**Barangaroo Headland Park and Northern Cove Main Works
Proposed Modification to Approval MP10_0048
Response to submissions**

ATTACHMENT

BARANGAROO HEADLAND PARK - CARPARK COMPARISON

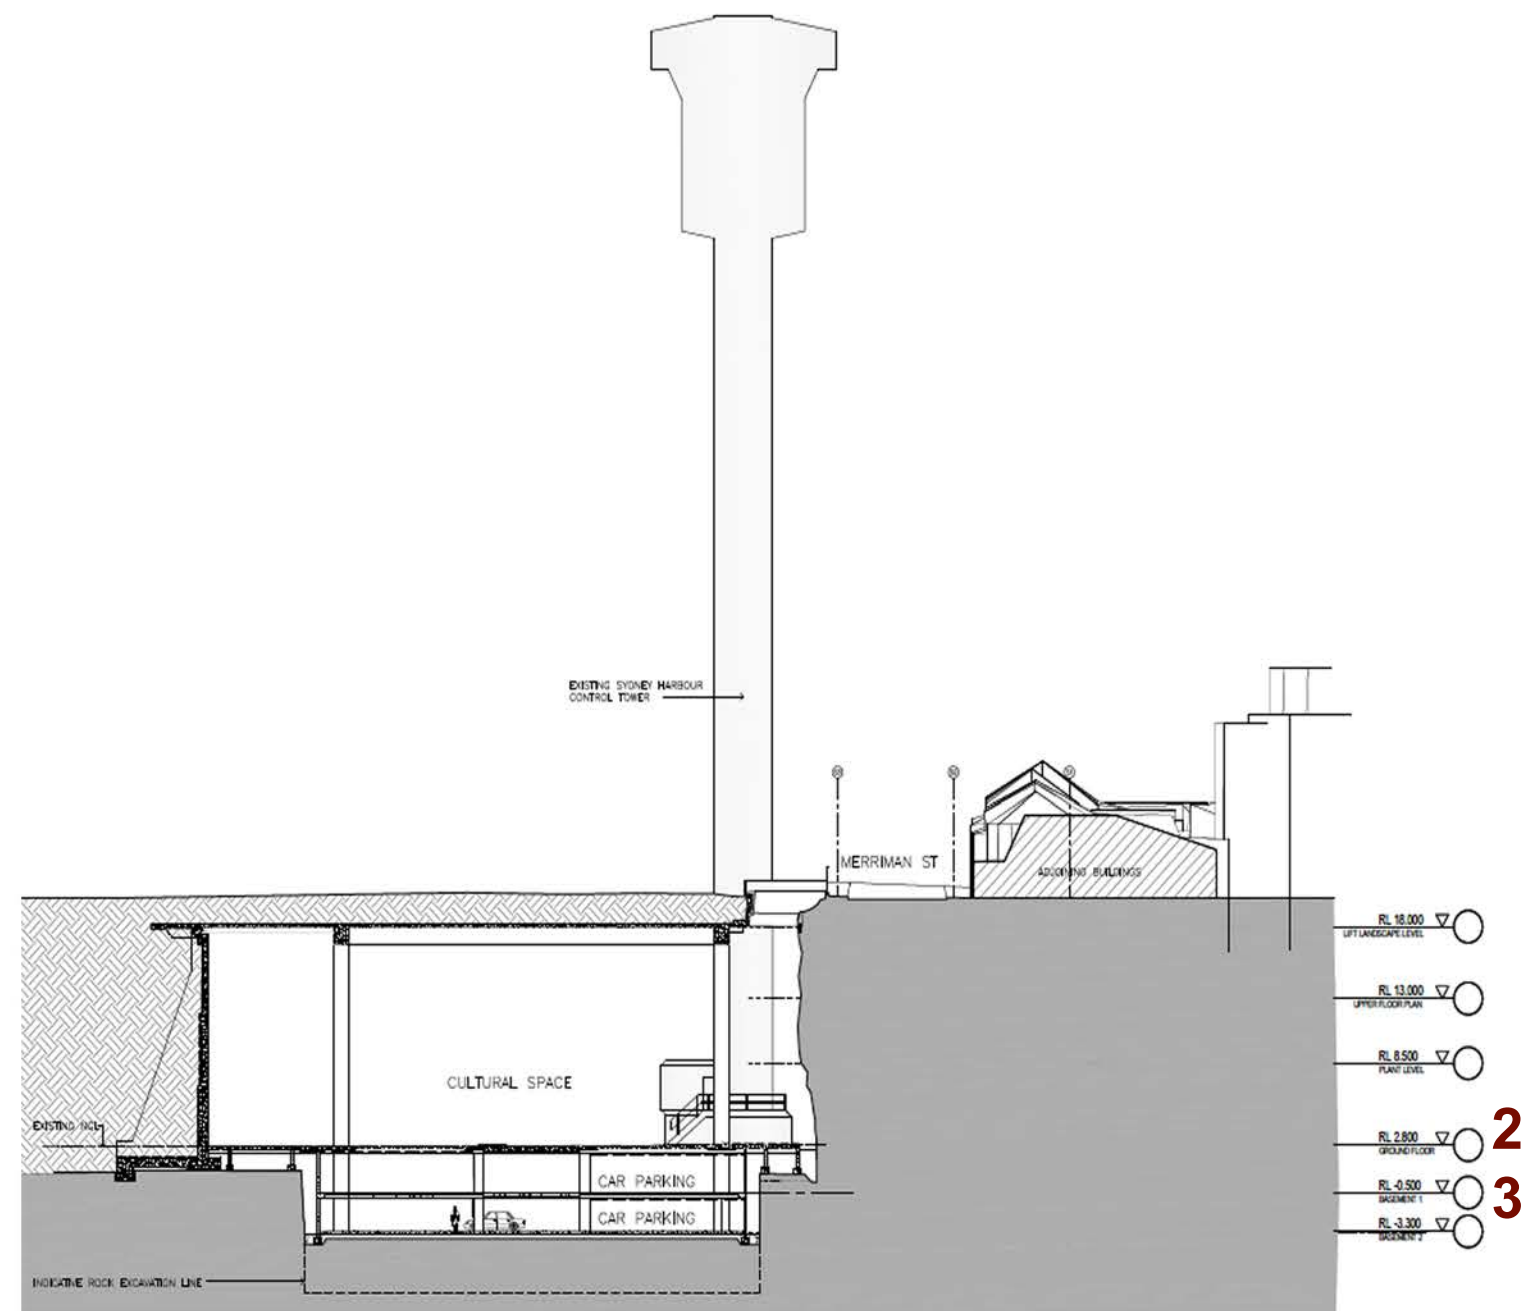
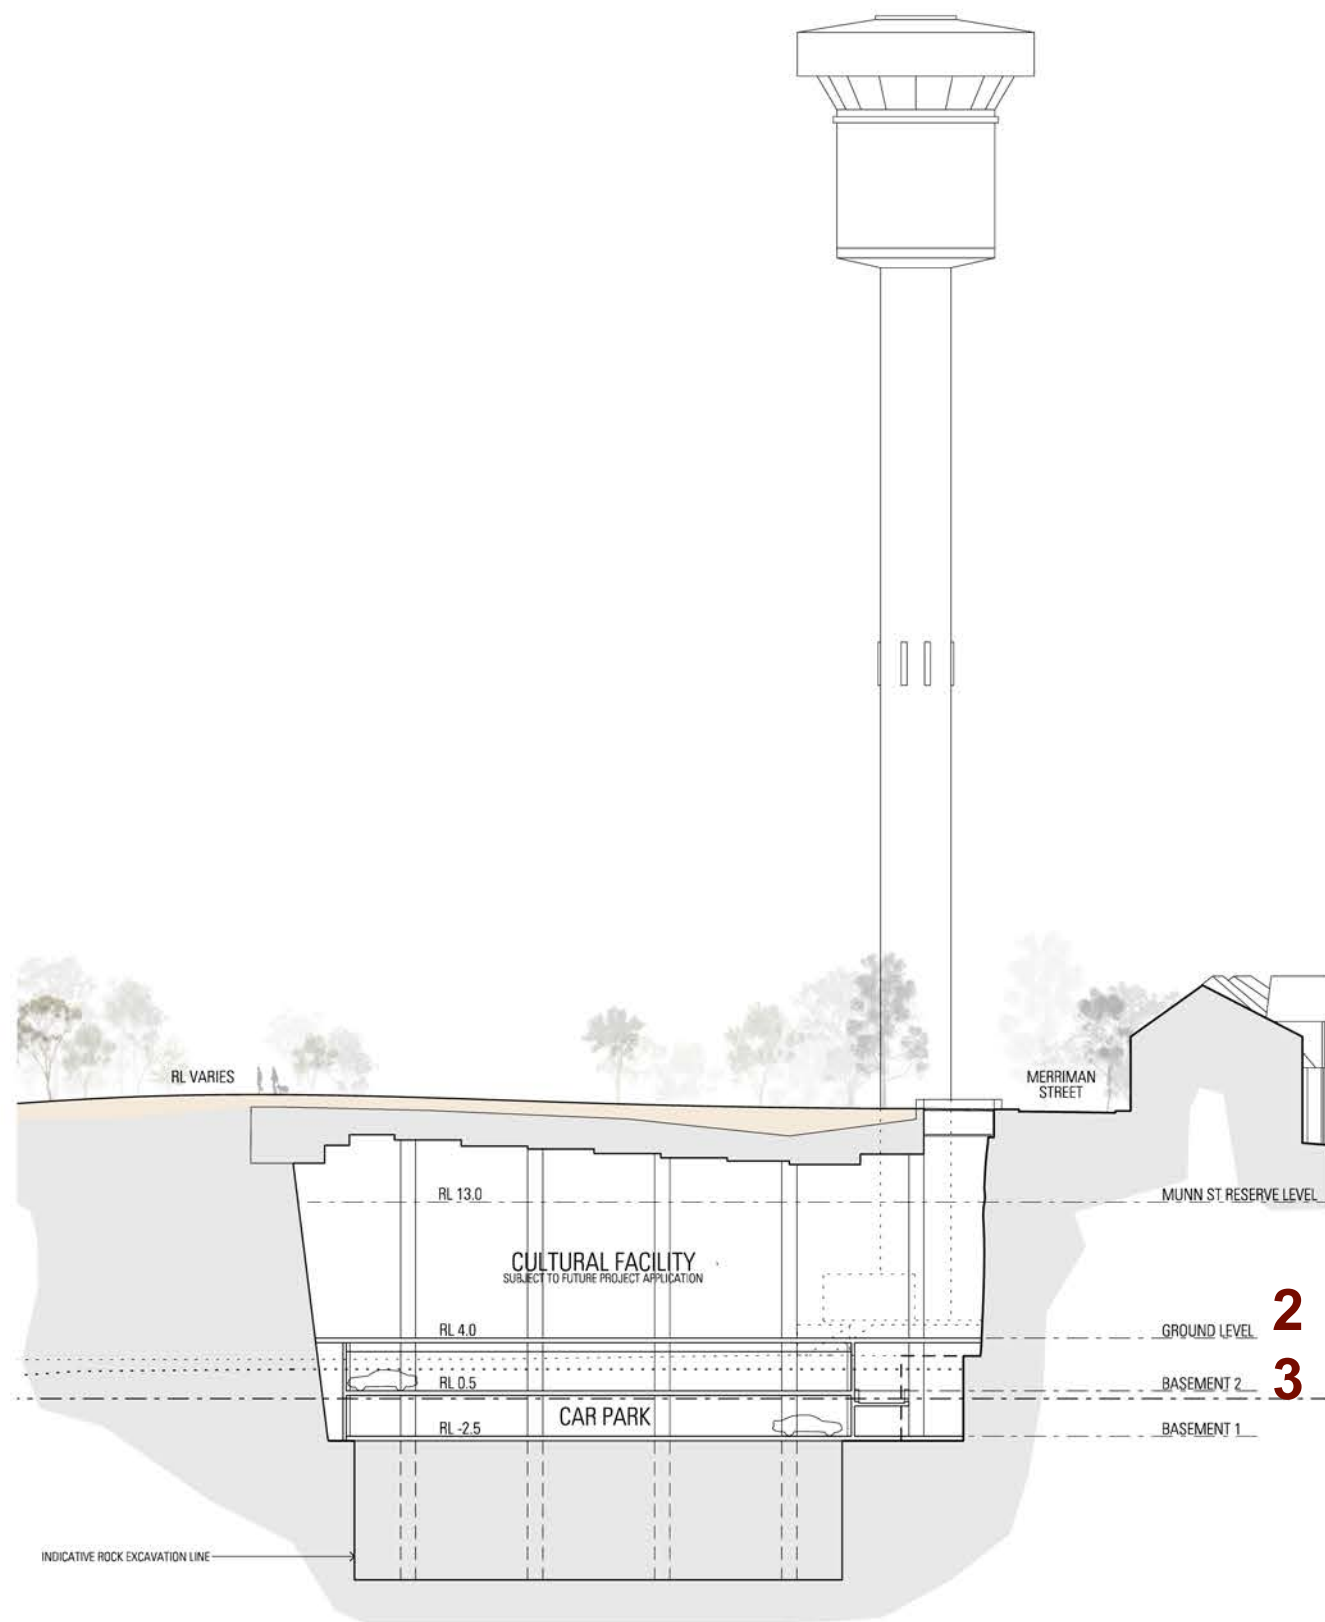
c. No objection to the modification.	Noted.
2.	Sydney Harbour Association	a. Broad support for the proposed modification. b. Query as to whether the allowance for future climate change that is assumed in the car park floor level indicated in the plans is adequate to accommodate the future development of climate science.	Noted. It has been assumed that the increase in sea levels by 2100 will be in the order of 900 millimetres. This projection is consistent with the sea level rise planning benchmarks for use in coastal hazard and flood risk assessments that are set by the NSW <i>Sea Level Rise Policy Statement</i>¹. The projection includes sea level rise, accelerated ice melt, regional variation and rounding². It is considered the most appropriate current reference point for

No.	Respondent	Issue	Response
			design. Adding this projection to the peak summer high tides (king tides) has allowed the design team to model and predict hydrostatic pressures – and associated seepage flow – in the sandstone seams and bedding planes surrounding the carpark. This flow prediction in turn has allowed the sizing of groundwater pump-out pits and associated pump equipment. This is common practice for any basement extending below the water table. In this case additional geotechnical work was required as a result of proximity to Sydney Harbour.

Project Number
12020
Drawing Number
CO-JPW-L-S3-0100

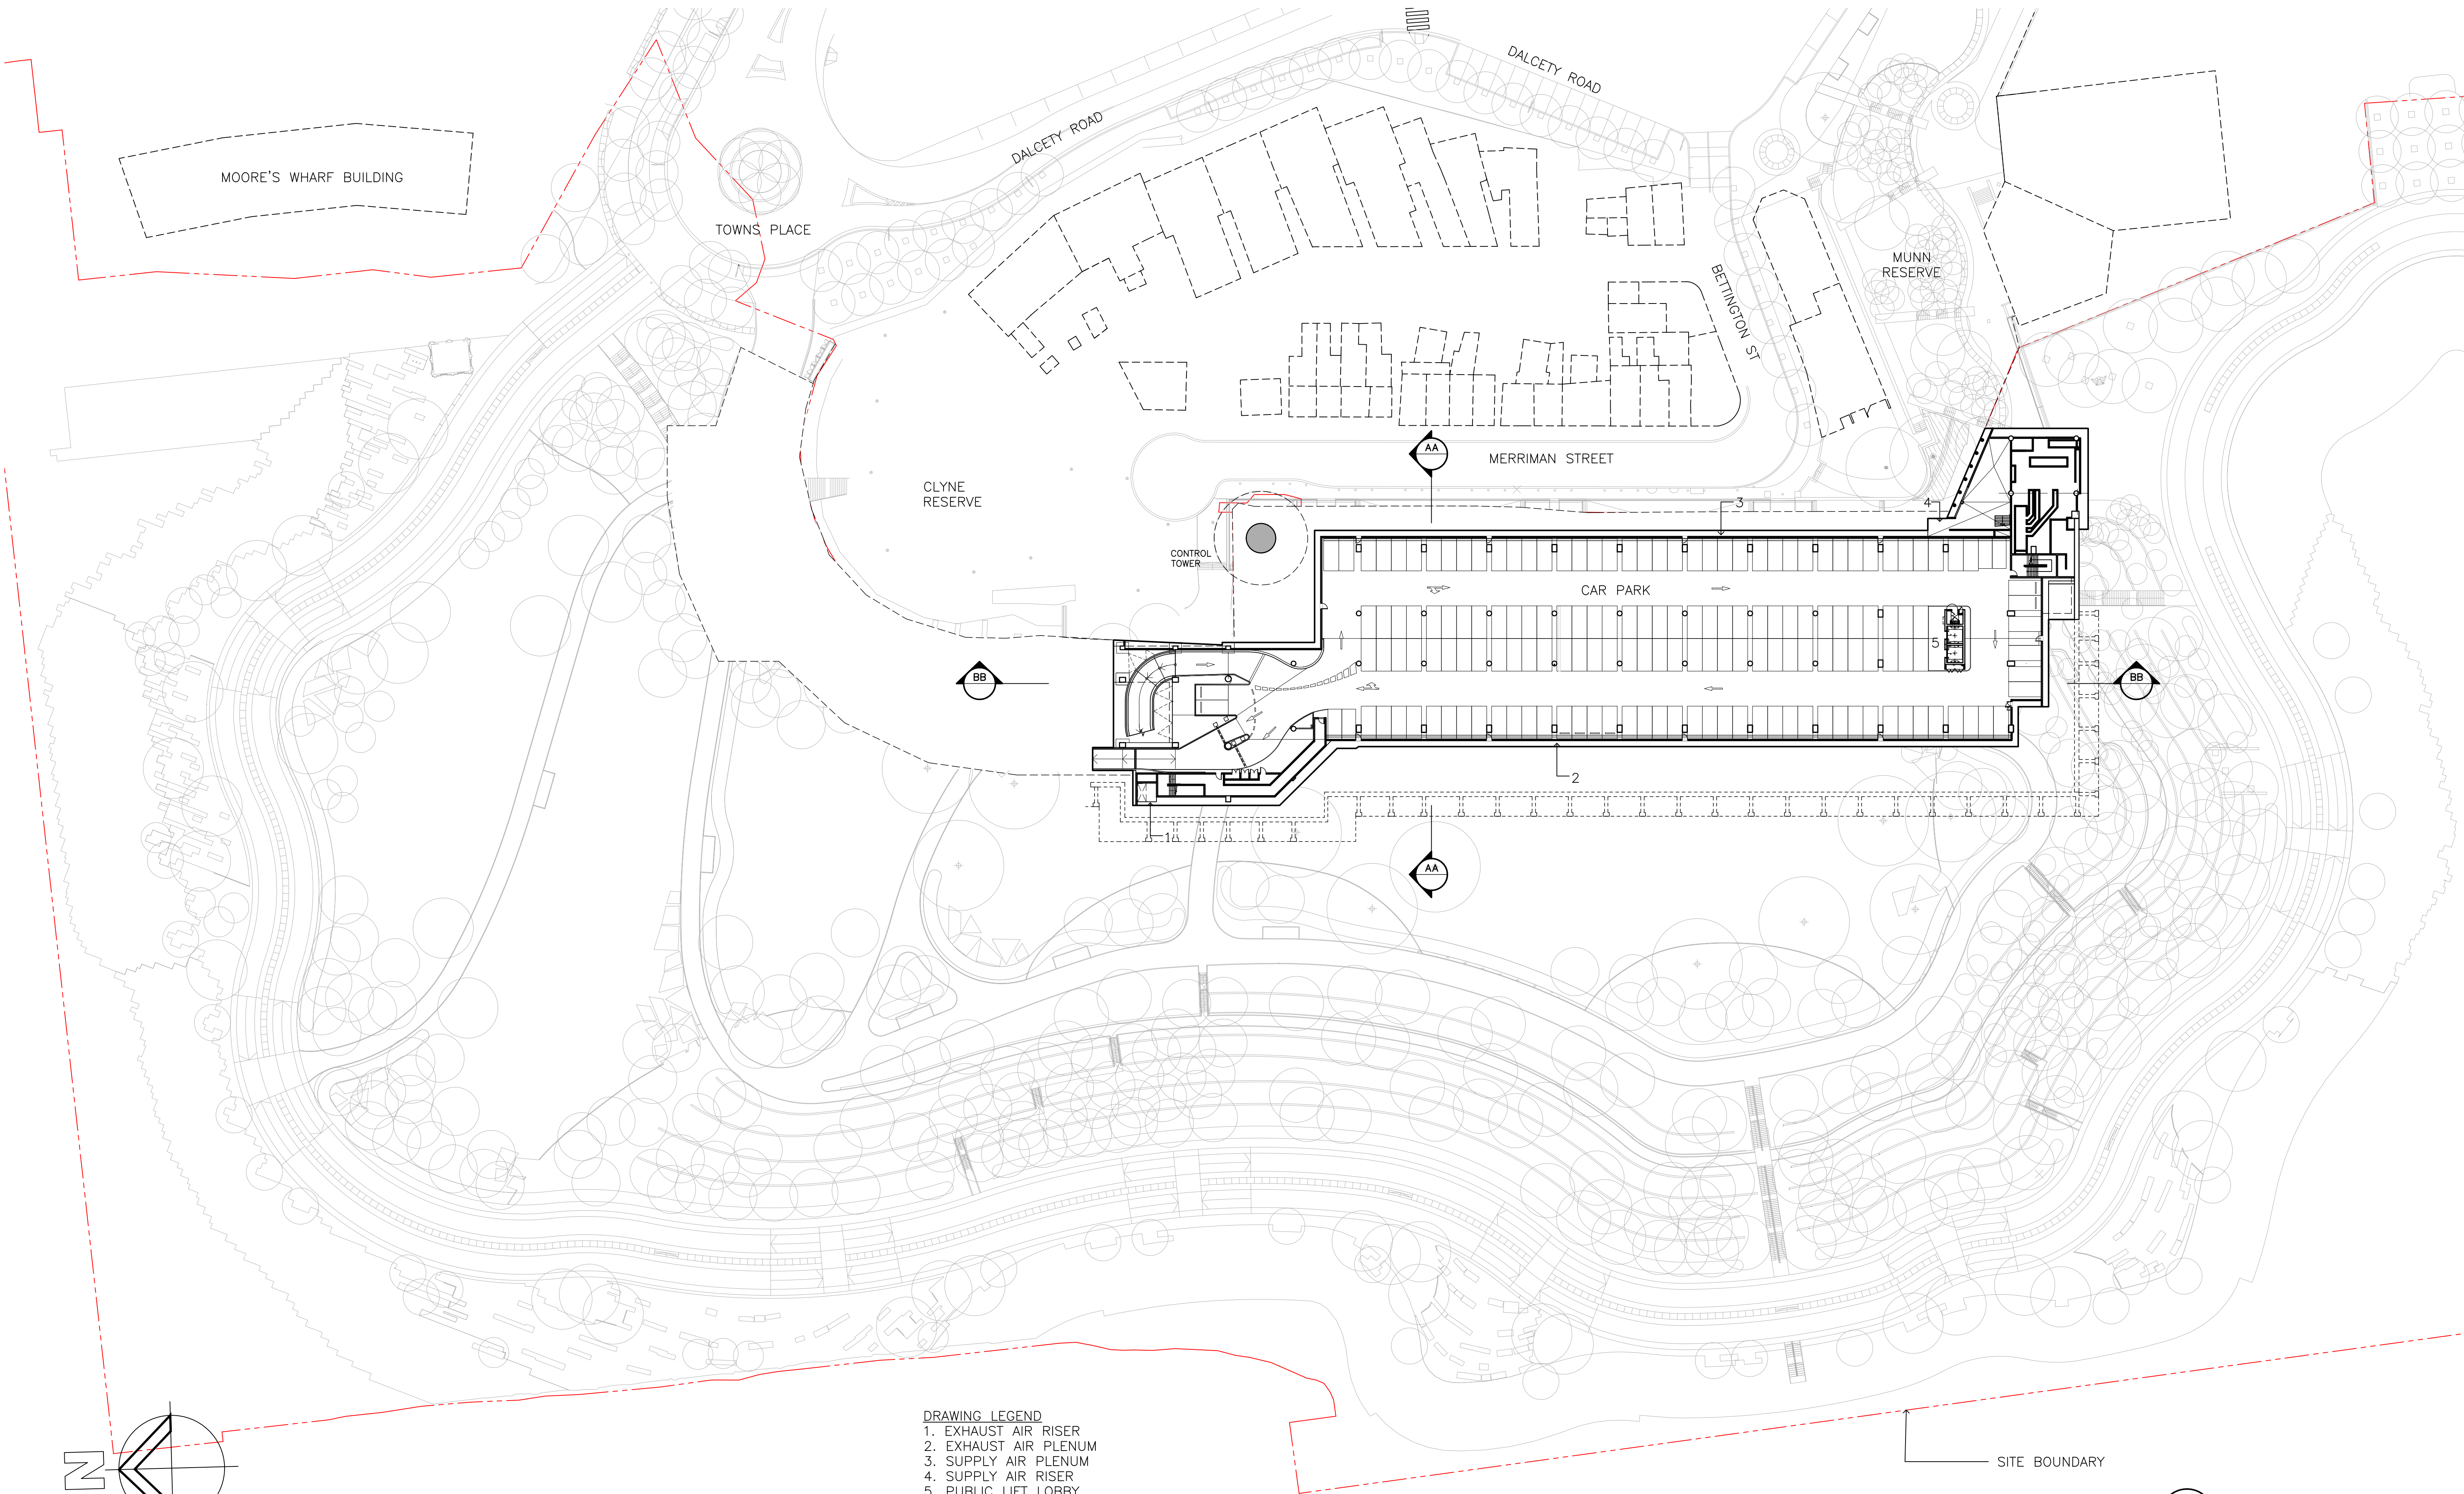
3.	Paul Wilson-Brown for the Residents of Merriman Street	a. Comment that Merriman Street is a very small cul-de-sac and that the maintenance of two access points more than integrates the street and park. Further comment that that the inclusion of a third access point is disproportionate to the street size and the extra public traffic that it will encourage. Suggestion that the purpose of the inclusion of the third access point on the street is to allow more access to the street by the public visiting the park with the view to making the street an extension of the park. Comment that that this comes at the expense of the residents' right to relative privacy	As noted in the modification application, the aim of the additional pedestrian access is to improve the integration of the parkland for present and future occupants of Millers Point, and in doing so, help develop a sense of ownership of the park. It is not expected to encourage additional pedestrian traffic but may mean a small change in the distribution of that traffic. The residents' right to privacy will not be impeded by a third access way into a parkland on the opposite side of a public street. This aspect of the proposed modification is supported by the City of Sydney. The City has noted that the additional pedestrian access would improve permeability along the eastern edge of the

No.	Respondent	Issue	Response
			park and assist access / egress.
		b. Comment that the modification application states that a palisade style fence will exist along the entire length of Merriman Street creating a clear boundary. Support expressed for this element. c. Comment that if a third access point is placed in the middle of the street with palisade fencing surrounding, it will act like a 'sheep run' and guide park visitors through the middle of the street to the detriment of the residents.	Noted It is expected that most visitors entering the park will do so via Munn Reserve. Park patrons looking to gain access to the top of the park will likely use the southern most walkway at Bettington Street as it represents the shortest and most legible route to the park from this location. The other two walkways serve to improve permeability along eastern edge of the park. The provision of three well defined access points at this location aims to balance creation of a park for the wide Sydney and NSW community with the concerns of local residents..

d. Concerns expressed regarding safety of residents, especially at night.	Headland Park will be a 24-hour accessible public open space in keeping with the approach to urban parklands within the Sydney area. The addition of a third pedestrian access would not materially affect safety and security outcomes at this location. An operational Plan of Management will be prepared prior to the opening of the park and will consider management of access points.
